Cockle Bay Park – Response to Agency Submissions

STAGE 1 SSSA AMENDED
CONCEPT PROPOSAL SK-4.03

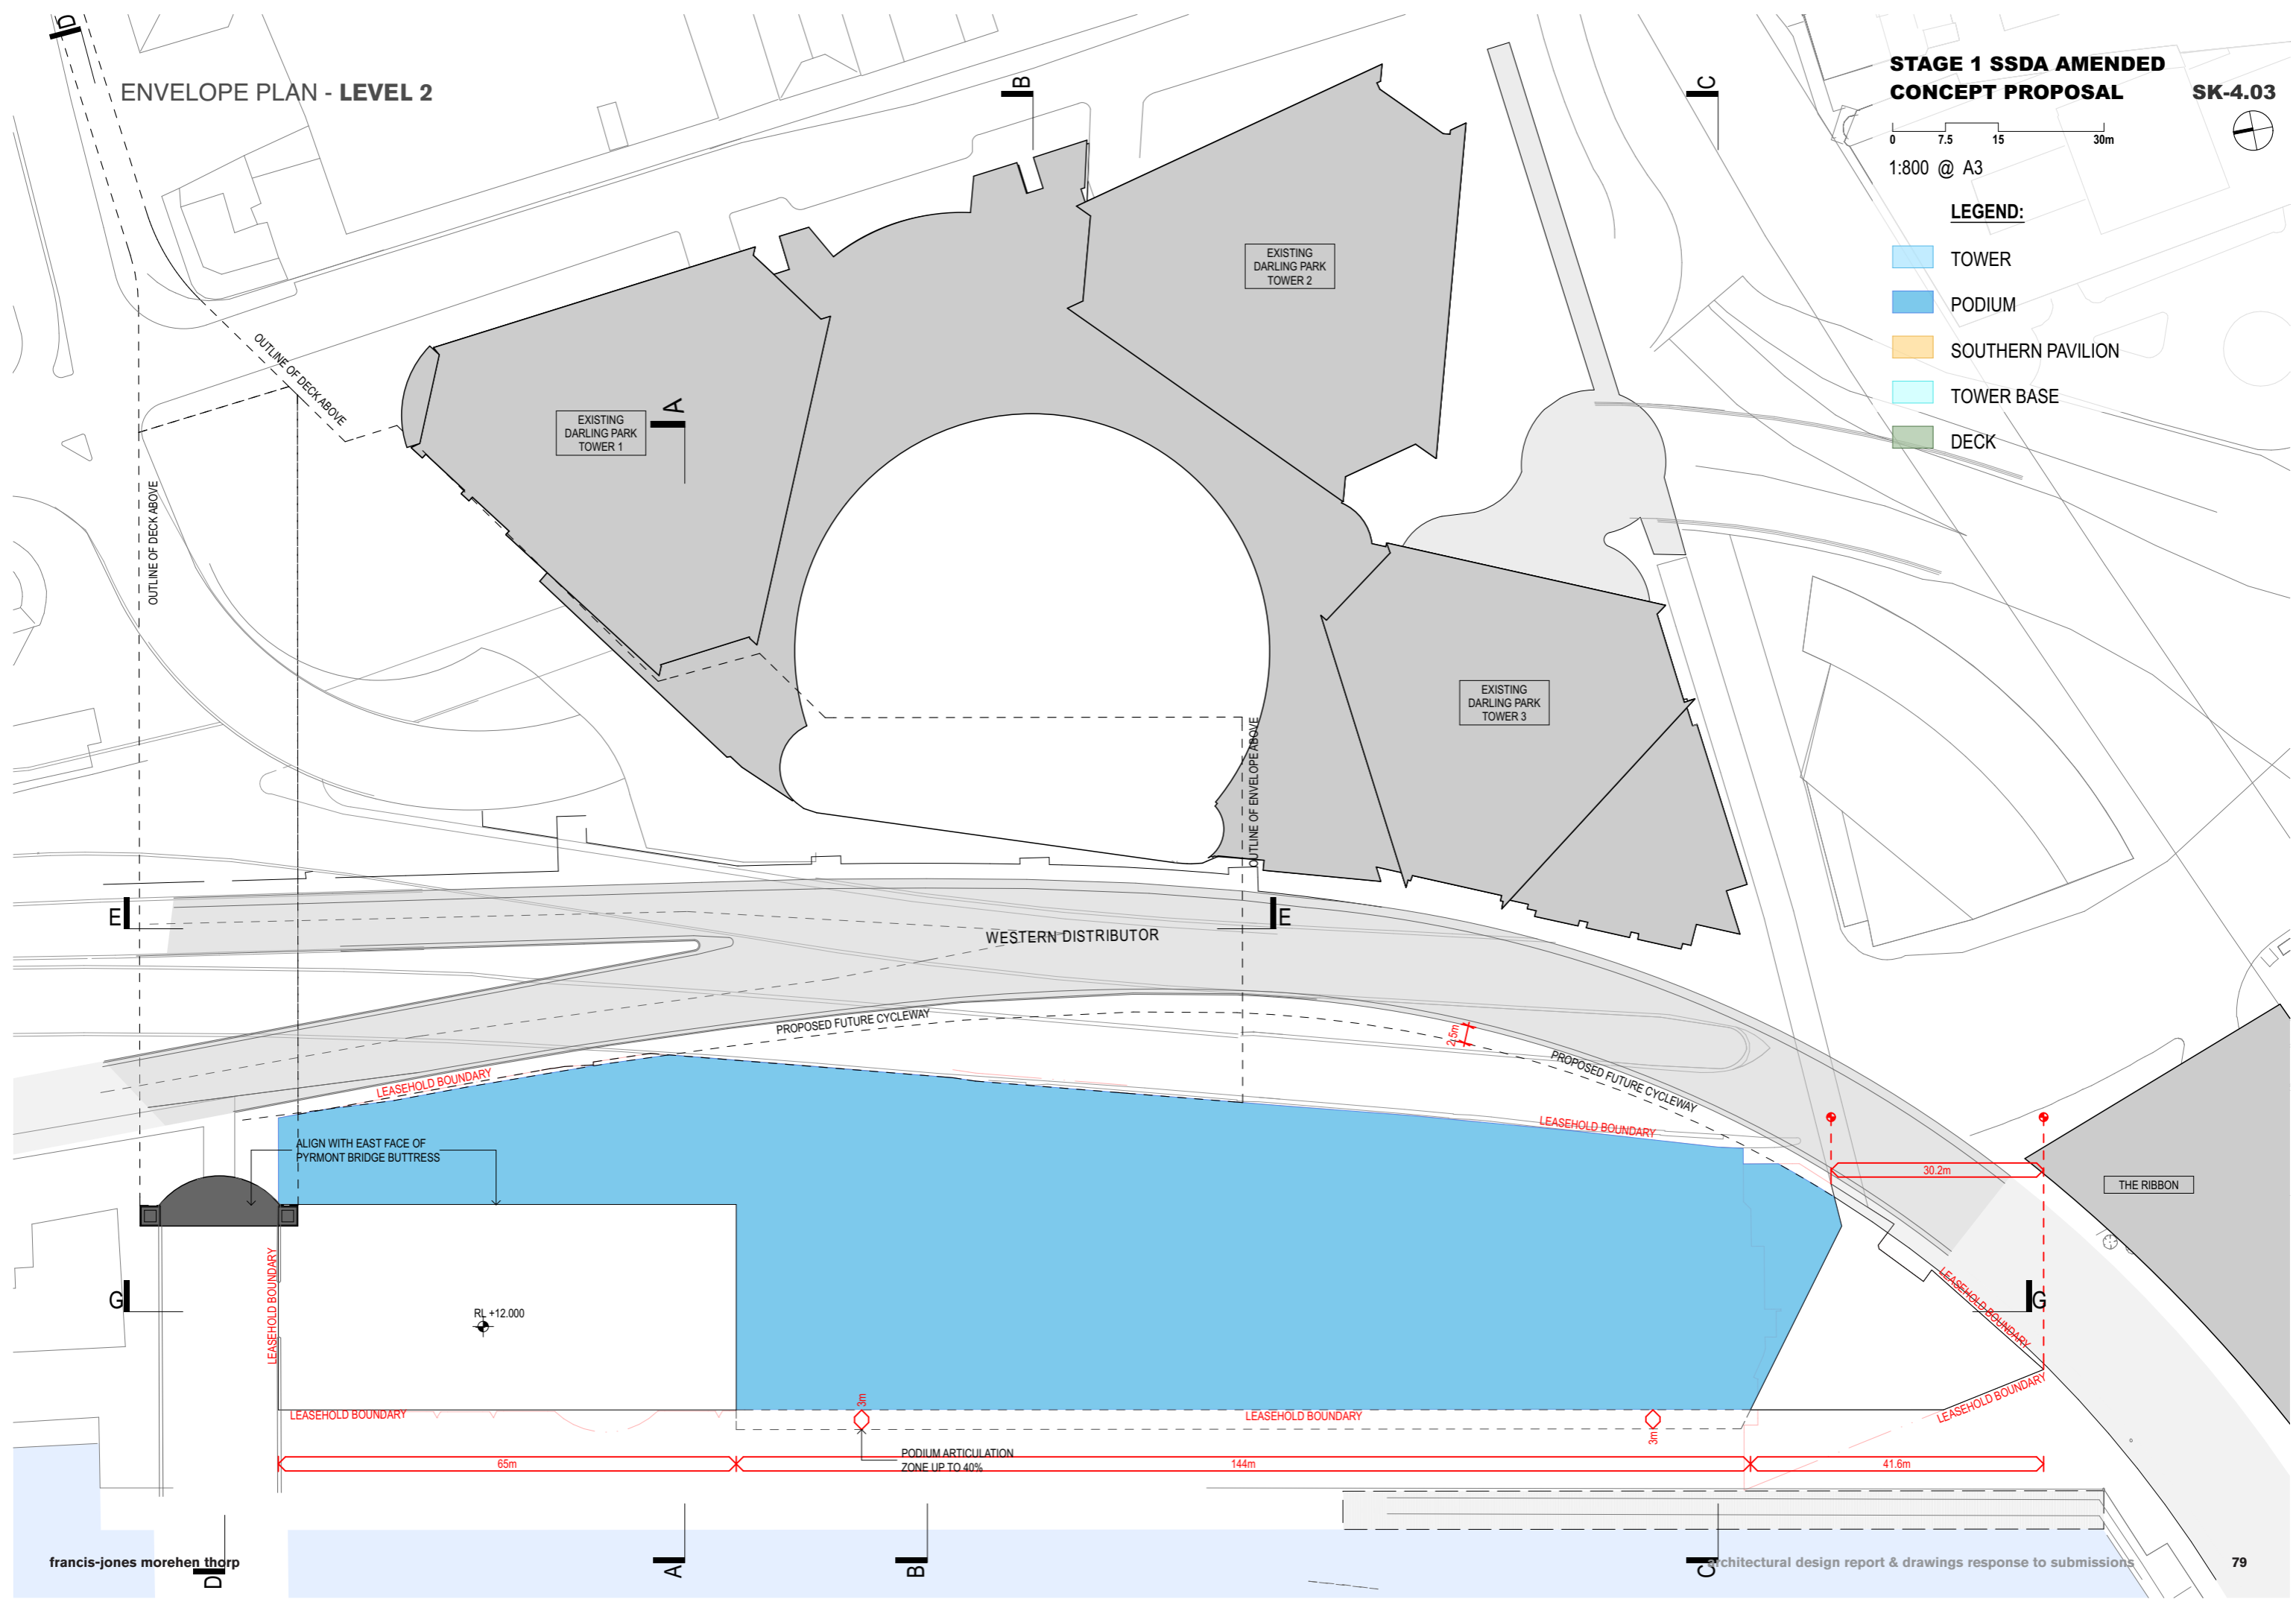
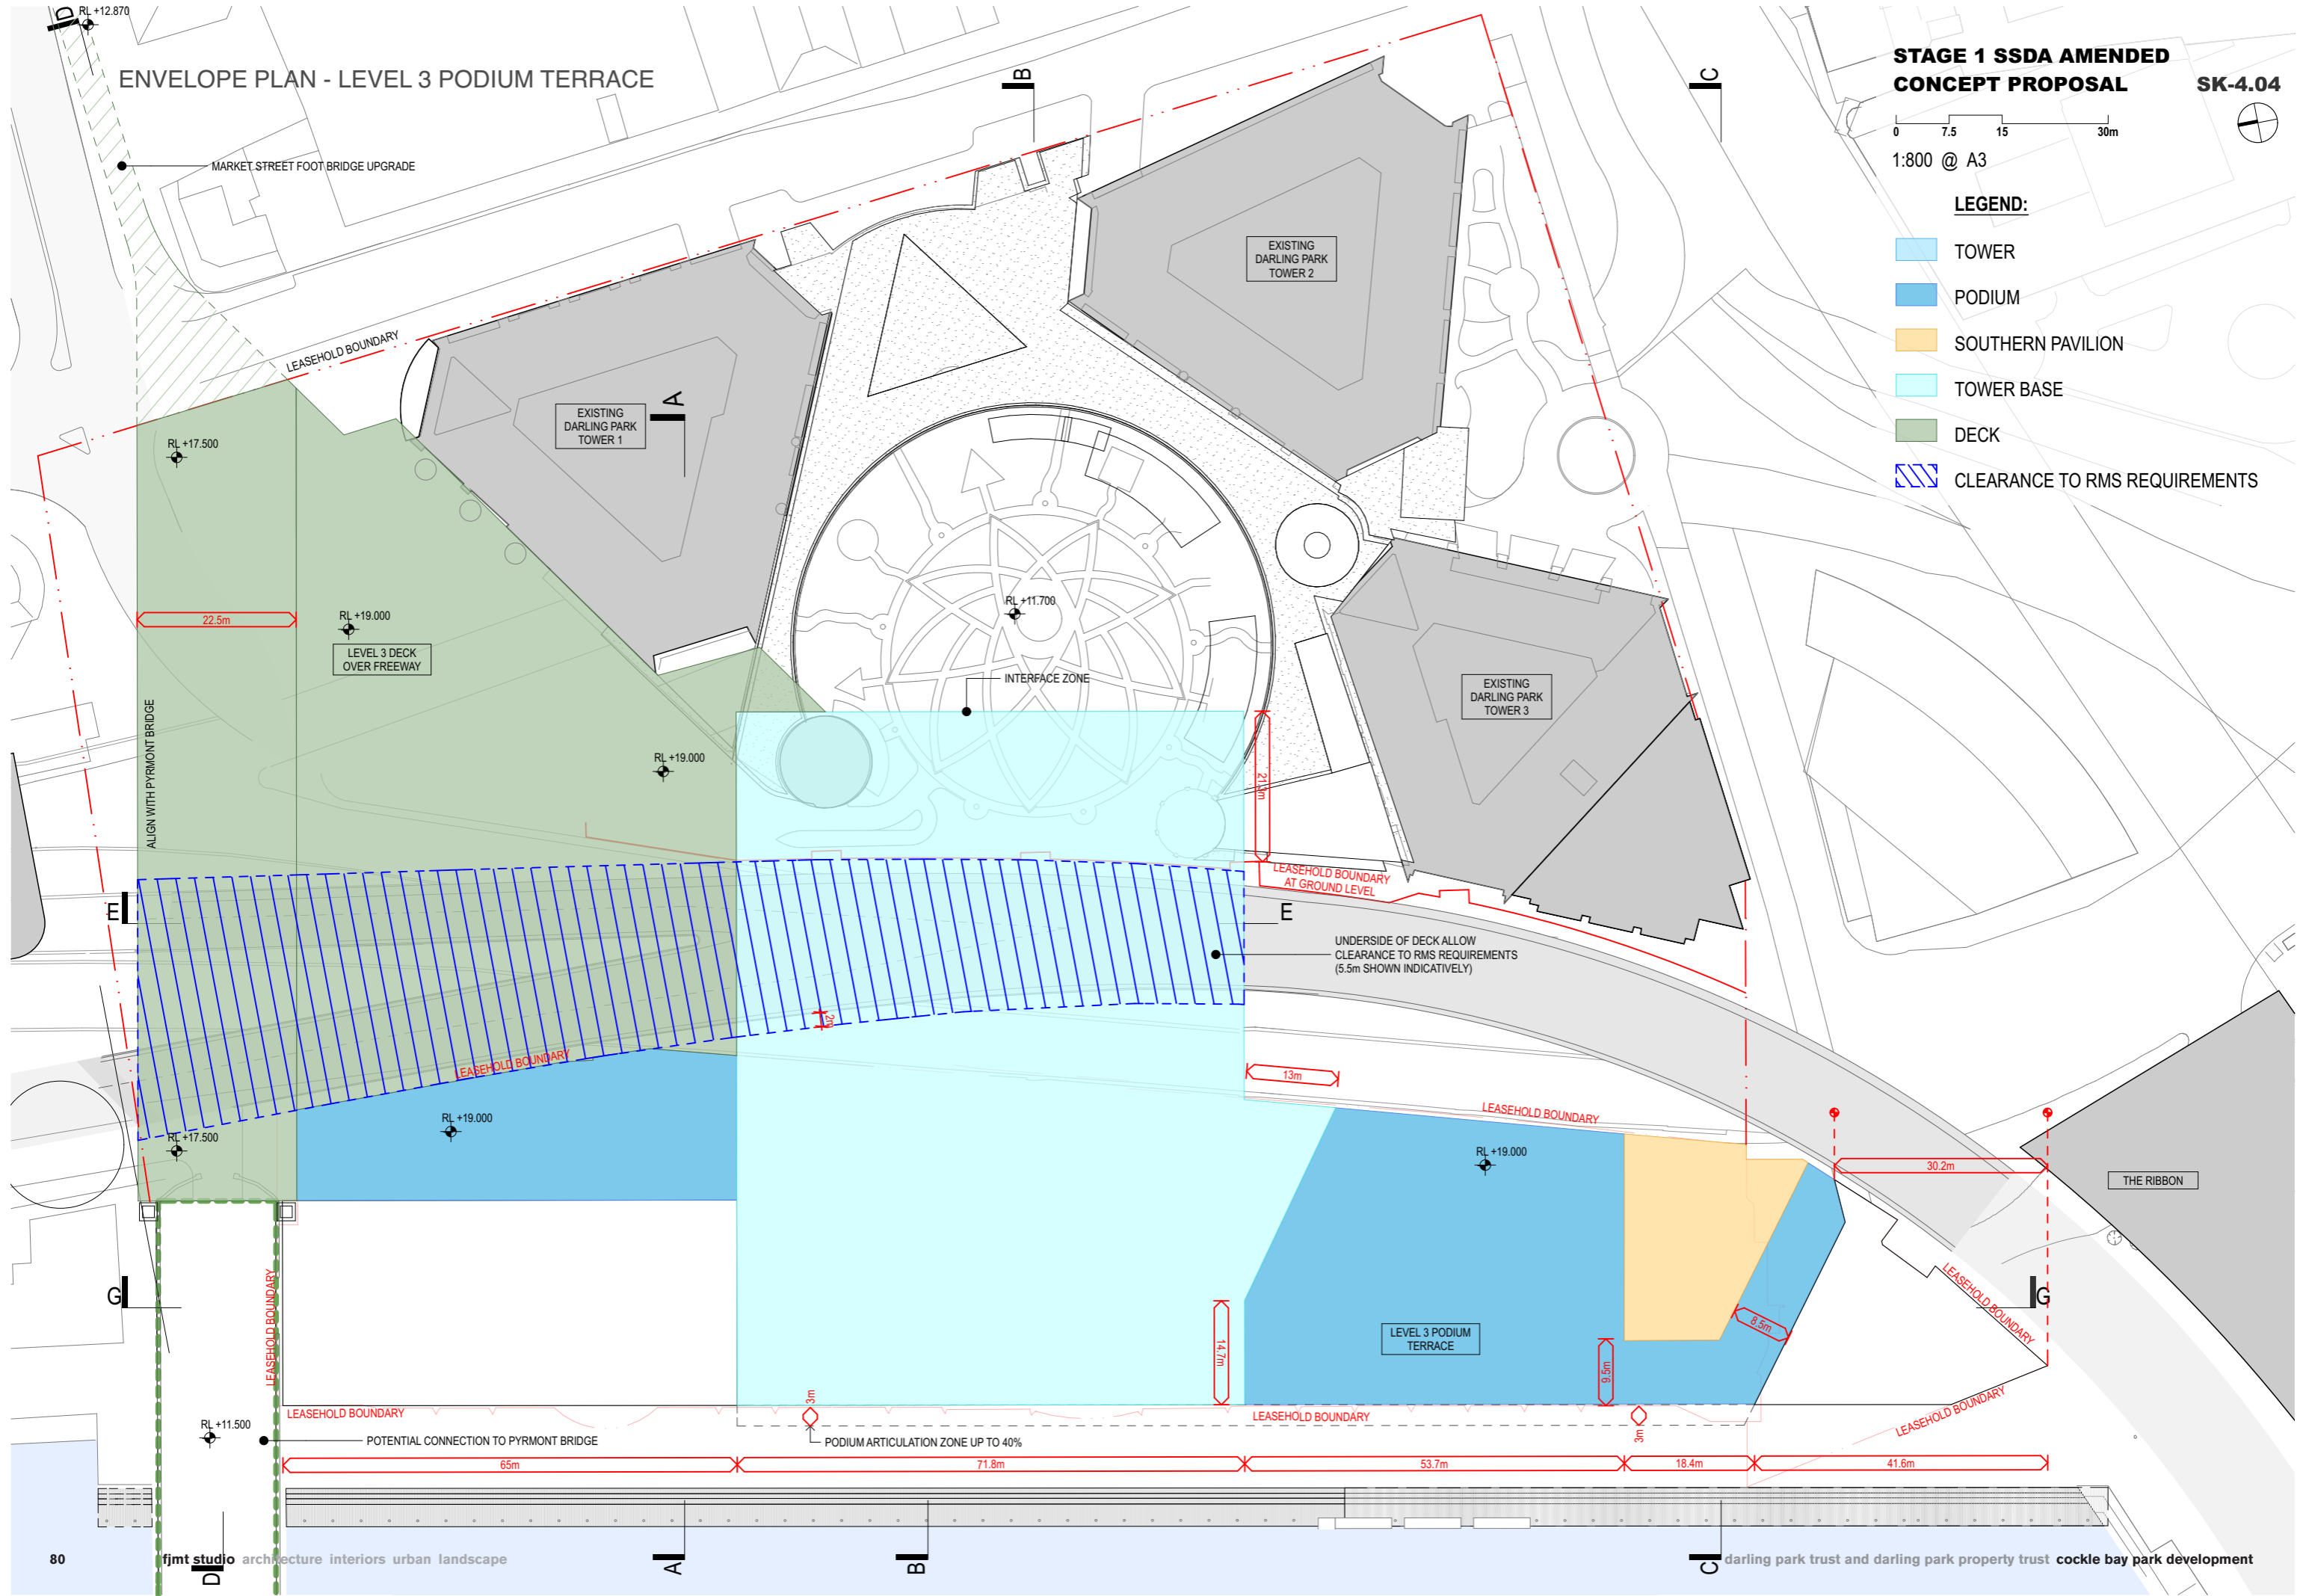
<p>The excessive bulk and scale of the proposal – the height and floor plate of the proposed commercial tower element;</p>	<p>The Concept Proposal has been amended since the exhibition of the EIS including:</p> <ul style="list-style-type: none"> • a 40 metre (17 percent) reduction in the height of the tower from RL235m to RL195m; • reduction in commercial GFA by 10,000m² (12 percent); • a reduction in retail GFA from 25,000m² to 14,000m² (44 percent); • reduction in the tower envelope footprint from 3,890m² to 3,575m² (8 percent); and

Item Raised	Proponent's Response
	<ul style="list-style-type: none"> the overall volume of the envelope has reduced by 153,000m³ (15.65 percent). <p>The amended Concept Proposal provides a proportional relationship to the existing buildings of Darling Park in consideration of height, separation and breadth so the precinct can be read as a whole. Building height and scale is further discussed at Section 7.6 and in the Architectural Design Report at Appendix C.</p>
<p>The bulk and massing of the podium and the relationship with the public domain, Pyrmont Bridge;</p>	<p>It is noted that the height of the existing Cockle Bay Wharf building is approximately RL19m, which is equal to the proposed height of the podium deck envelope. Accordingly the proposed podium at Level 3 will be of a similar scale to the existing development on Site which is considered acceptable.</p> <p>The amended Concept Proposal has revised the bulk and massing of the podium envelope to strengthen its relationship to the public domain and Pyrmont Bridge. This has been achieved through the following amendments:</p> <ul style="list-style-type: none"> reduce the volume of the Southern pavilion by reducing the height from RL31m to RL29m with the introduction of a minimum setback of between 8.5m and 9.5m from the lease boundary; increase the setback to the southern side of Pyrmont Bridge from 2m to 65m at Level 2 of the Podium; provide a new 44m (east-west) separation between the northern podium envelope (above Level 1) and the waterfront; reduce the length of the podium articulation zone along the foreshore from 209 m to 144 m, reducing the overall podium volume; include provision to extend the boardwalk (5m wide) which would further increase the spatial relationship between the podium and waterfront; and consolidate publicly accessible open space adjacent to Pyrmont Bridge. <p>The amended Concept Proposal will elevate the significance of the public domain by knitting the Site</p>
